Ribble Valley Borough Council
Planning Section
Council Offices
Church Walk
Clitheroe
BB7 2RA

Phone: 0300 123 6780
Email: developeras@lancashire.gov.uk
Your ref: 3/2026/0254
Our ref: 3/2026/0254/HDC/LB
Date: 18/05/2026

Location: 19 Mearley Syke, Clitheroe, BB7 1JG
Proposal: Proposed two storey side and rear extension

SITE PLAN 1:200

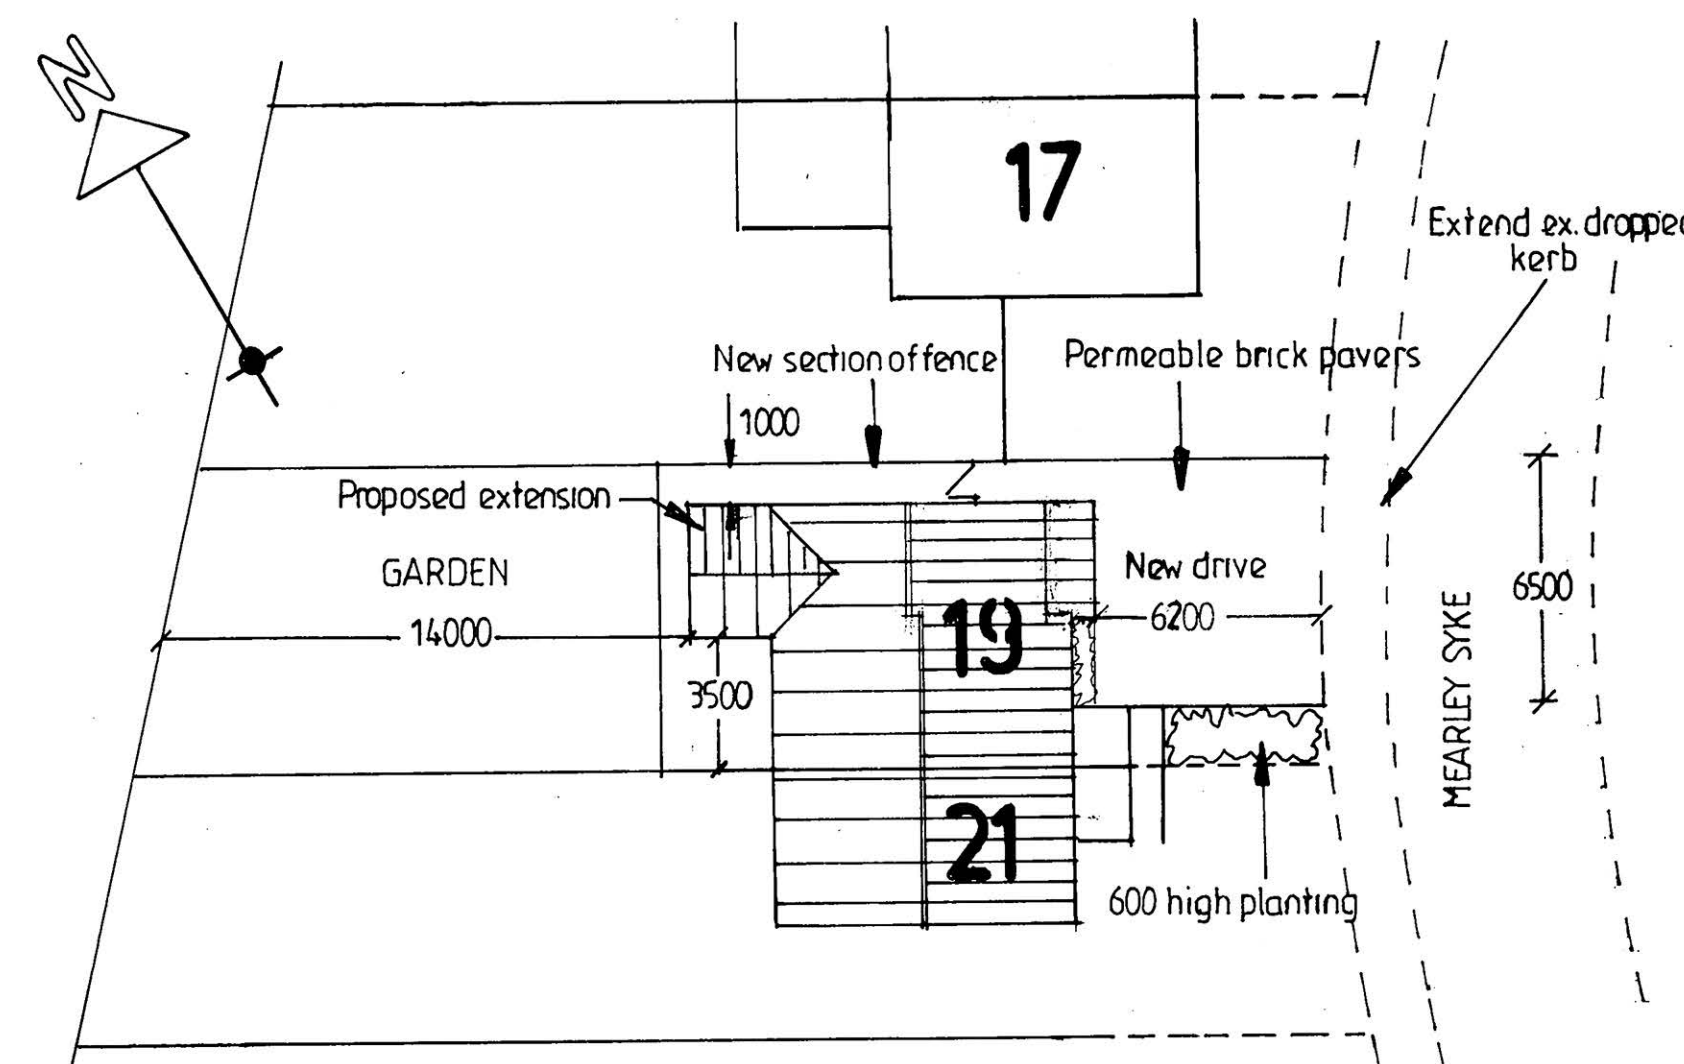
As shown in submitted drawing 'Proposed Plan 2/44/2026', the driveway and vehicle crossing are to be widened.

To safely accommodate two off-street parking spaces, each space should each measure 5m in length and 2.4m in width. As the driveway would also serve as a pedestrian access to the dwelling, an additional 0.2m width should be provided, resulting in a minimum driveway width of 5m.

To accommodate the scale and nature of the dwelling, we request that the existing dropped kerbs are widened at the carriageway edge and the vehicular cross-over extended across the driveway to an adequate width.

- a) Prior to occupation, the existing dropped kerbs must be widened at the carriageway edge and the vehicle cross-over constructed across the footway fronting the site in accordance with Lancashire County Council Specification for Construction of Estate Roads, it is then to be retained in that form thereafter for the lifetime of the development.
